# Rezoning Transportation Analysis

Petition Number: #2022-126

**From:** Jake Carpenter, PE

Date	Description
12-29-22	First Review (TM)
1-24-23	Second Review (DR)

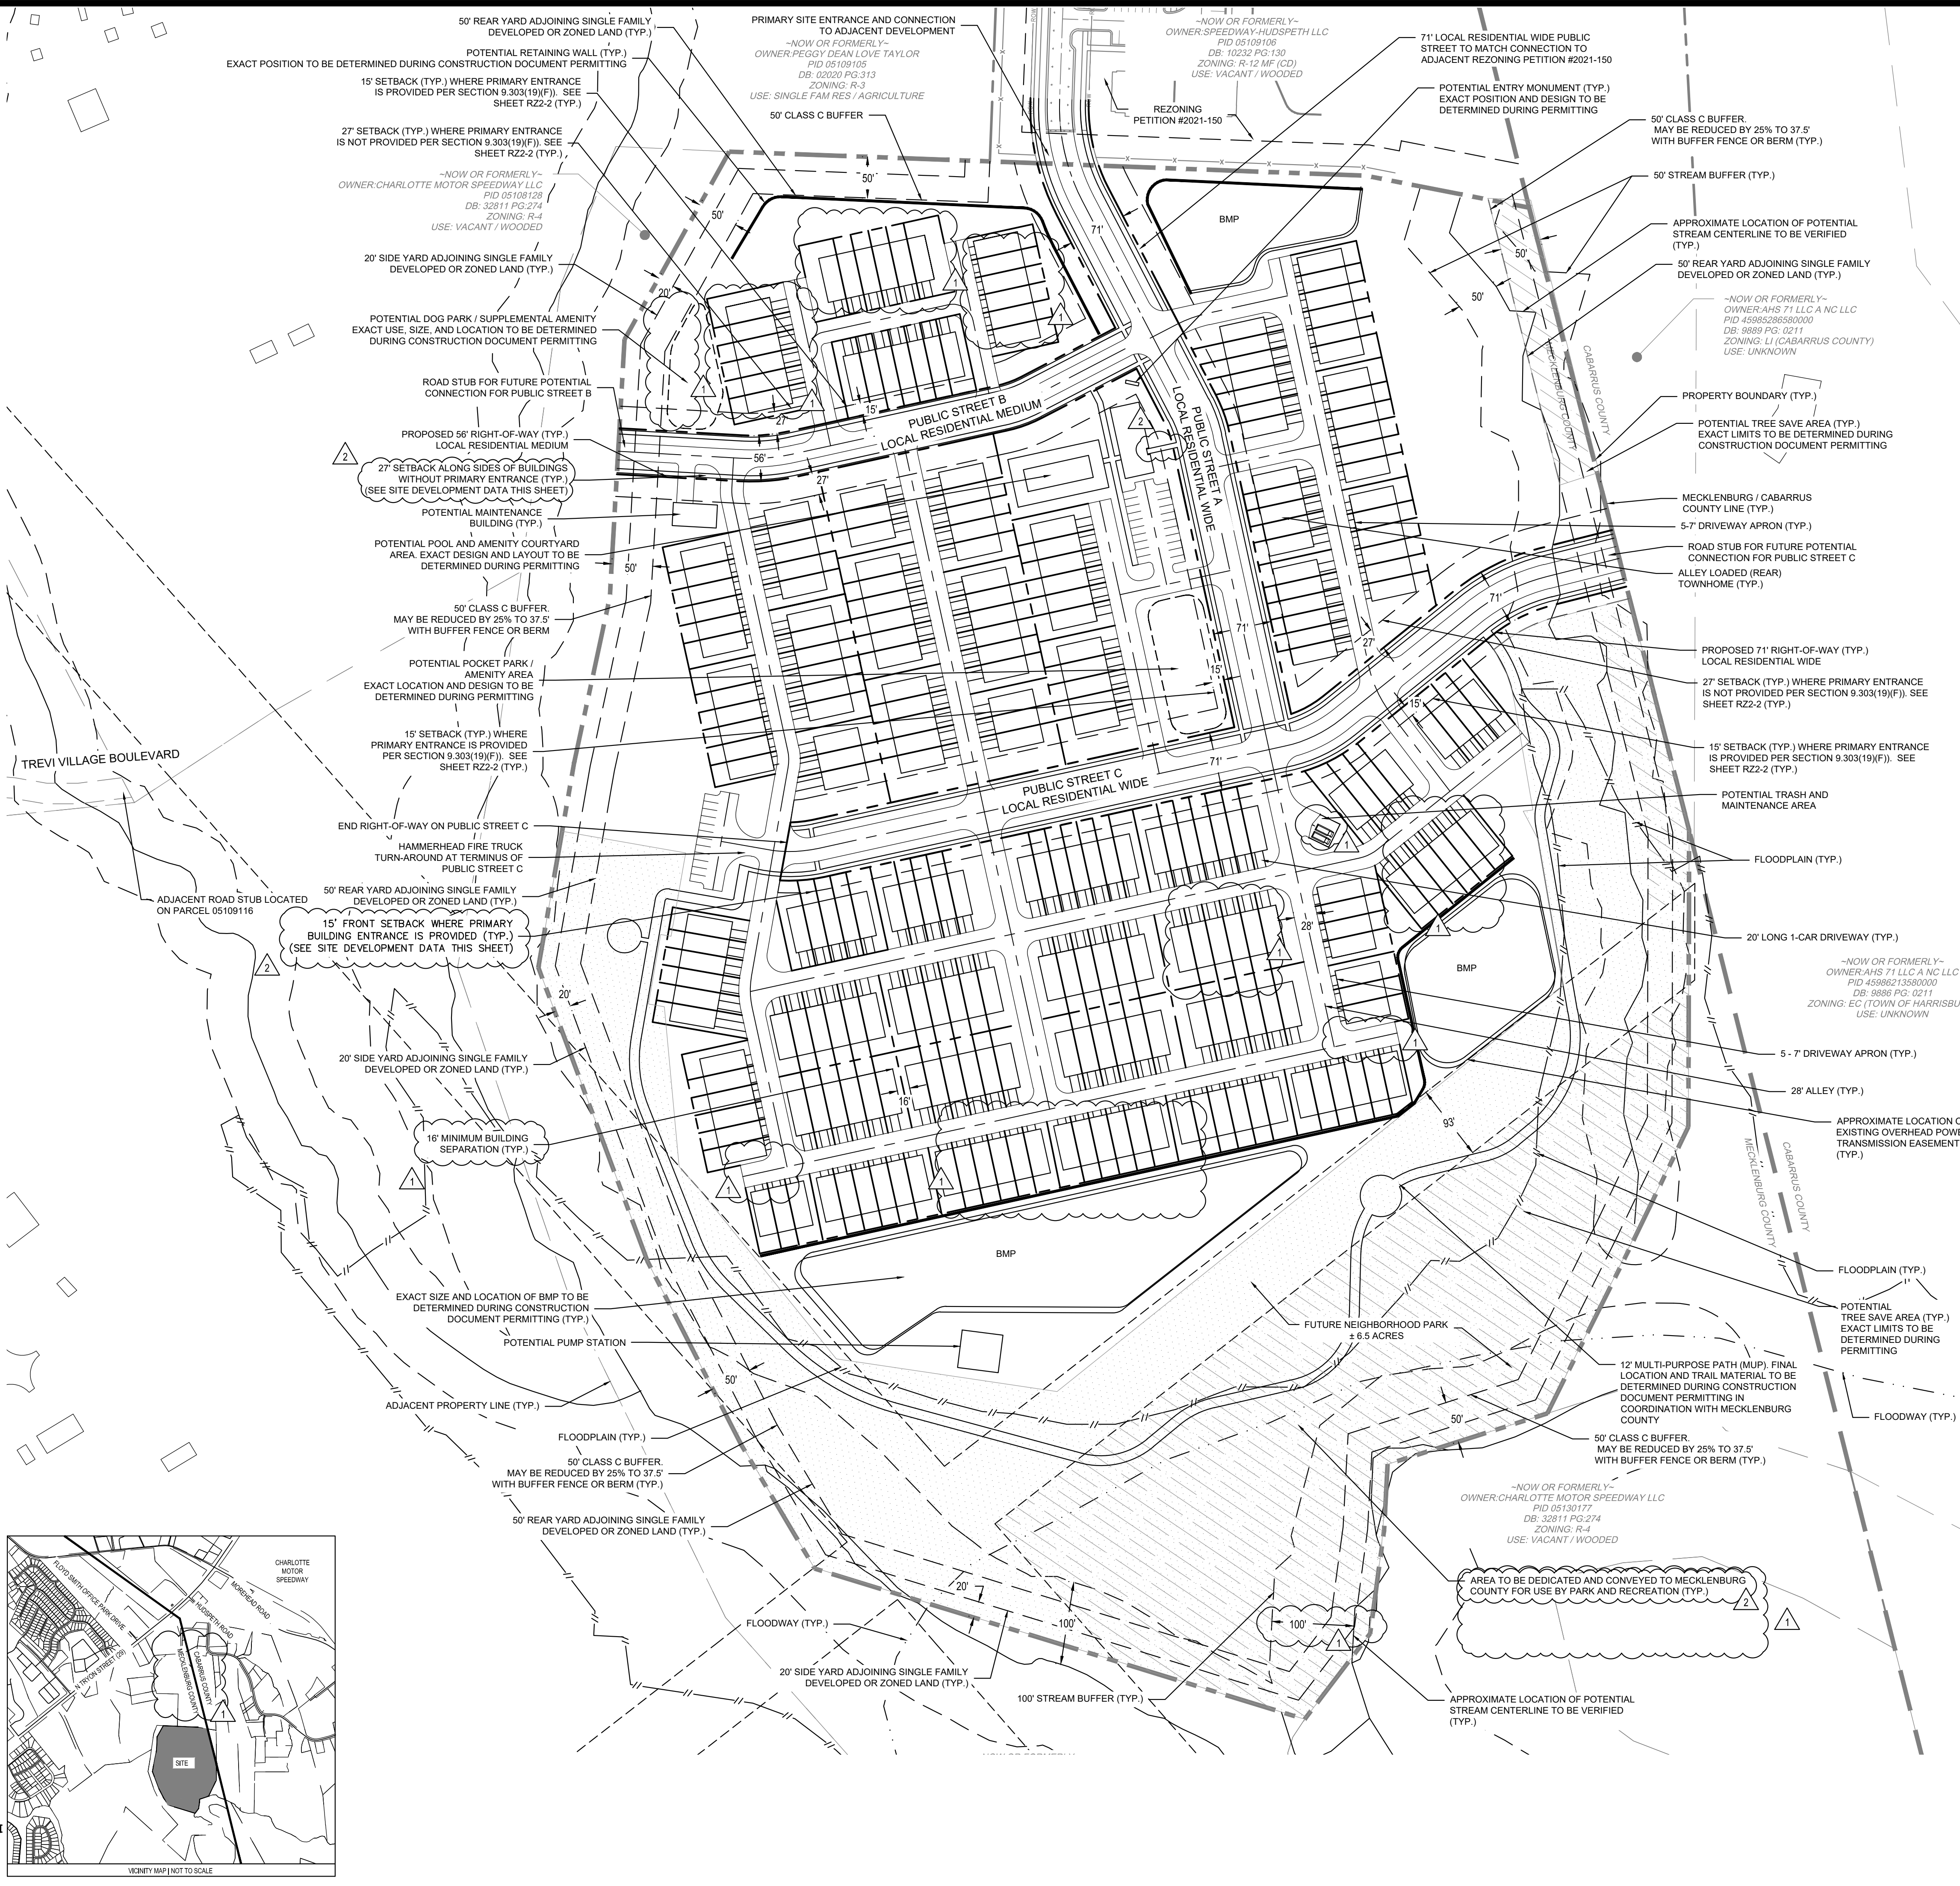
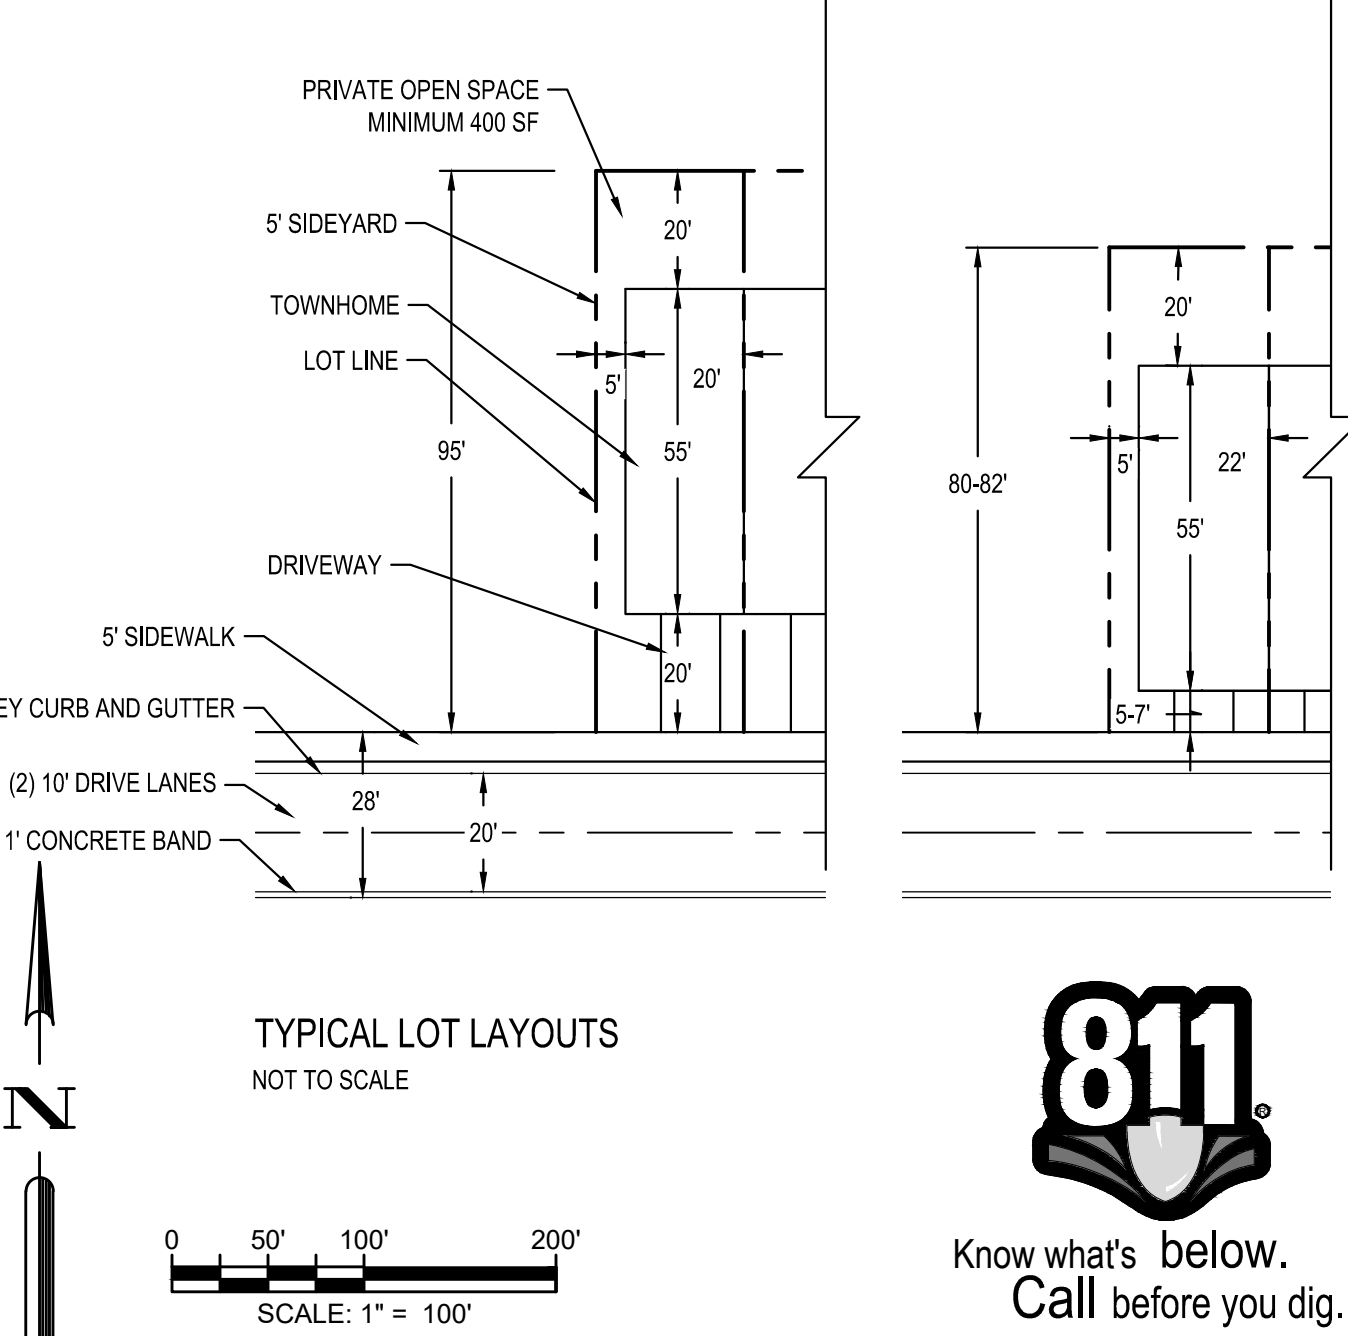
- Show entirety of Public Street A as a Local Residential Wide. Add CLDSM roadway typical section for Local Residential Wide.

**Clarifying comment from 1/24/2023:** Add CLDSM roadway typical section for Local Residential Wide (CLDS U-03A) to sheet 2.
